Ribble Valley Borough Council
Council Offices
Church Walk,
Clitheroe
Lancashire
BB7 2RA

Phone: 0300 123 6780
Email: developeras@lancashire.gov.uk
Your ref: 3/2025/0231
Our ref: 3/2025/0231/HDC/KW
Date: 17 July 2025

Location: 3 Church Street Clitheroe BB7 2DD

Proposal: Change of use from hot food takeaway (sui generis) to two ground floor commercial units (Use Class E) and a HMO on the first, second and third floors (Use Class C4). Installation of new shop front in converted garage to rear opening into the council car park. Building works to rear to include partial demolition and rebuild of existing rear single-story extension, conversion of garage to rear, insertion of rooflights and new door to main building.

1 Proposed Site Plan  
1:100

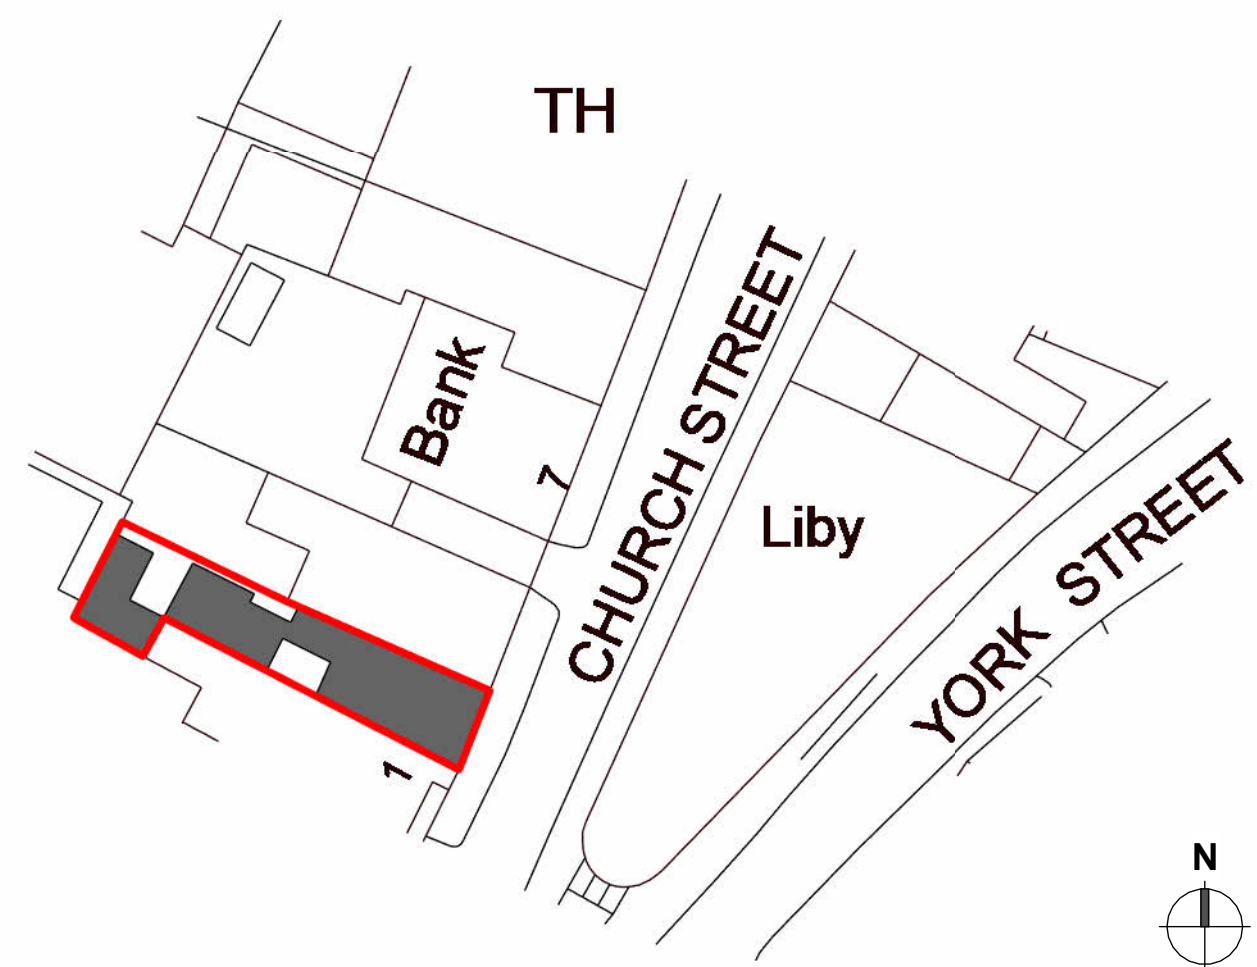
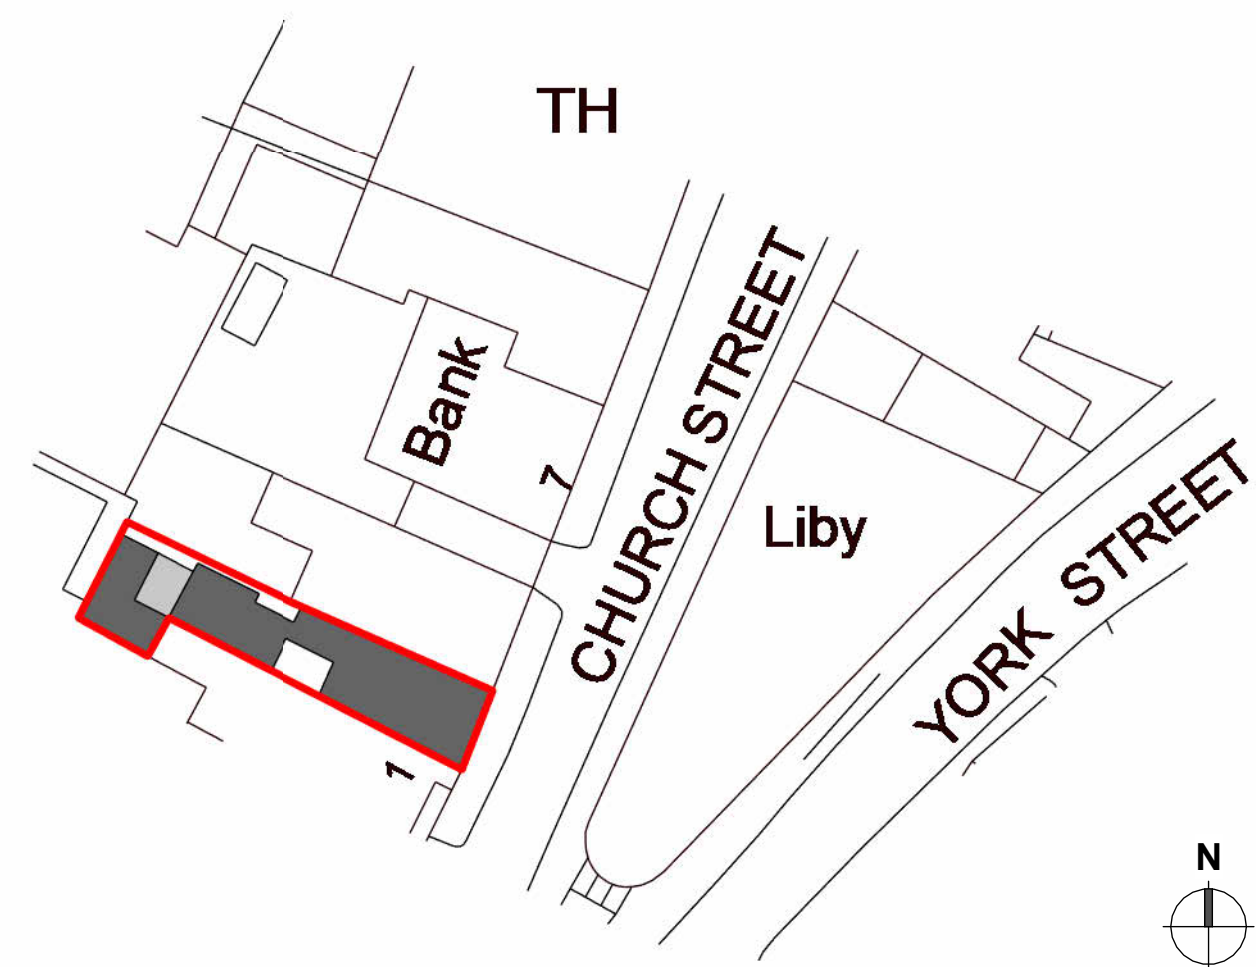
Therefore, the development shall include covered secure cycle storage for one bicycle space per bedroom to ensure the provision and availability of adequate cycle parking for each resident and the promotion of sustainable forms of transport.

2. Prior to first occupation, secure, covered cycle storage provisions for a minimum of 5 bicycles for the residential unit shall be submitted to the Local Planning Authority, in consultation with the Local Highway Authority. These cycle facilities shall thereafter be kept free of obstruction and available for the parking of bicycles only at all times.
Reason: To promote sustainable transport as a travel option, encourage healthy communities and reduce carbon emissions.
